BCA ASSESSMENT REPORT

**SYD05-06-07 DATA CENTRE
MAMRE ROAD, KEMPS CREEK**

Revision 0

Date: 22 March 2021

Drawing Title  
ELEVATIONS - SYD05-06

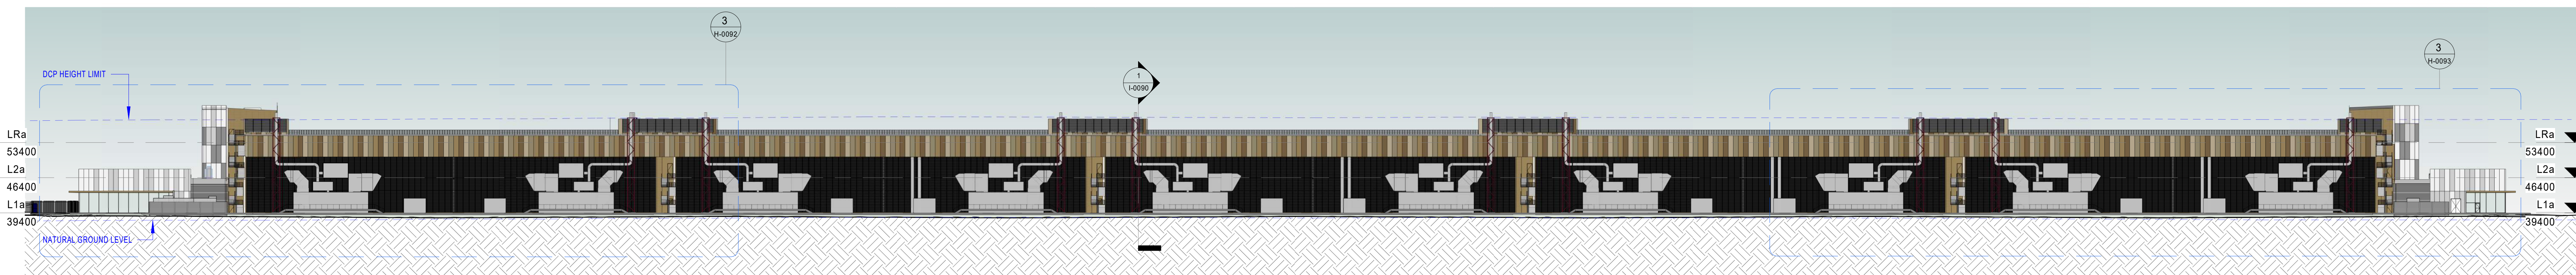
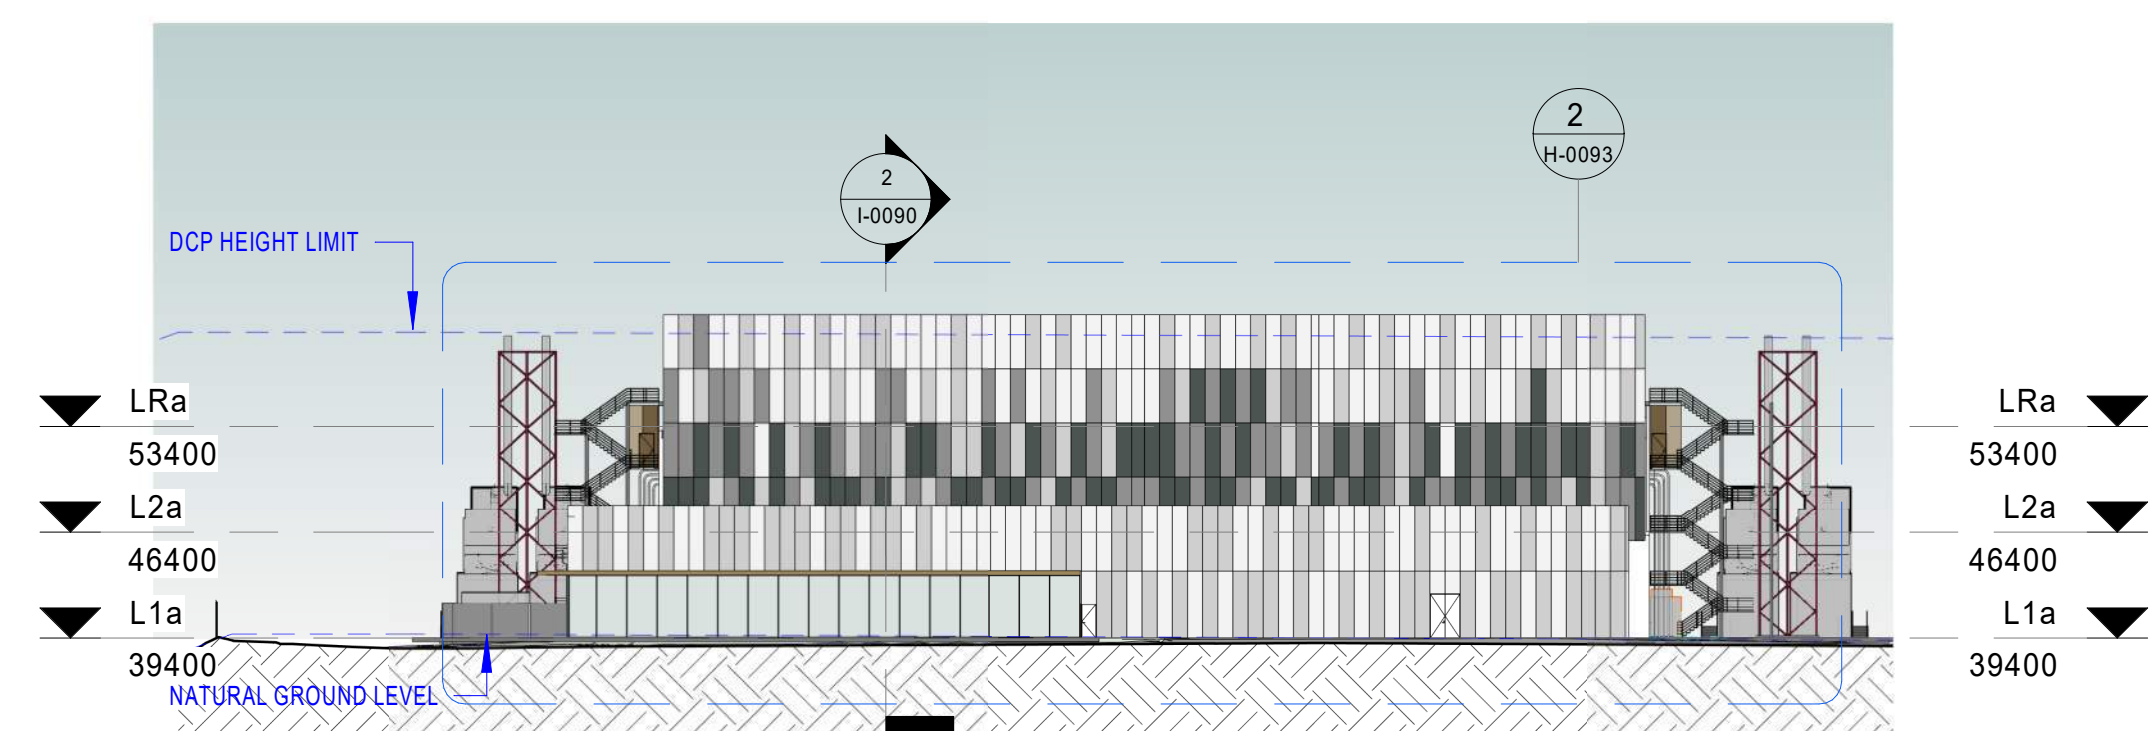
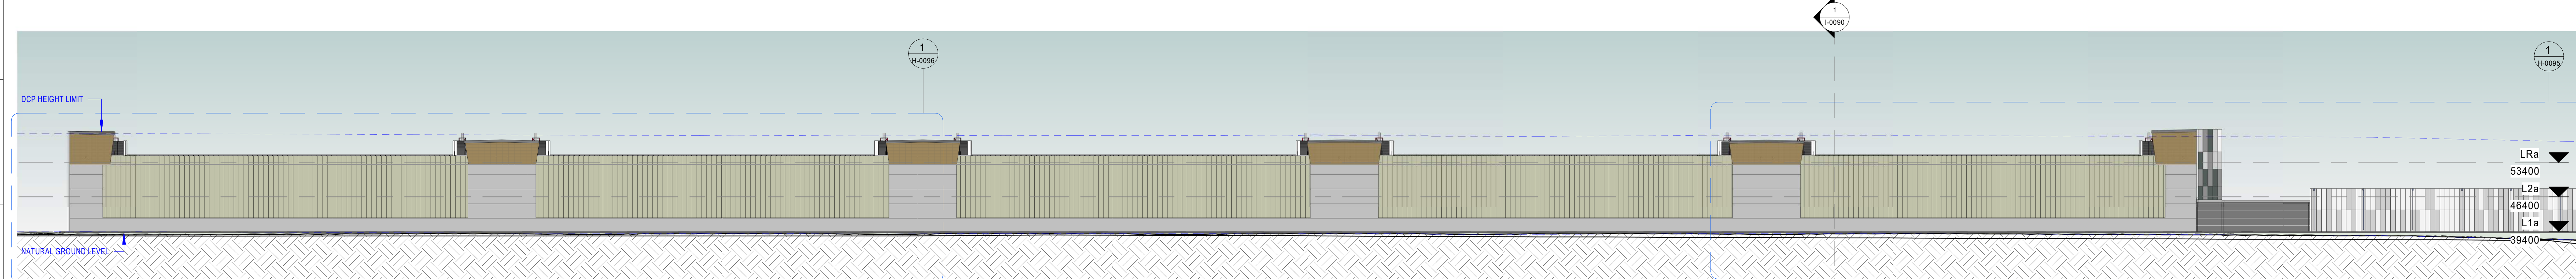
Note: The coloured architectural elevations indicate that Aluminium Panel Cladding is proposed to be used on the façade and as such details of the proposed product and confirmation of its compliance with Clause C1.9(e), and or Verification CV3 (along with all other materials incorporated in the external walls) will be required to be provided in the form of a schedule and/or External Wall Disclosure statement at CC Application stage.
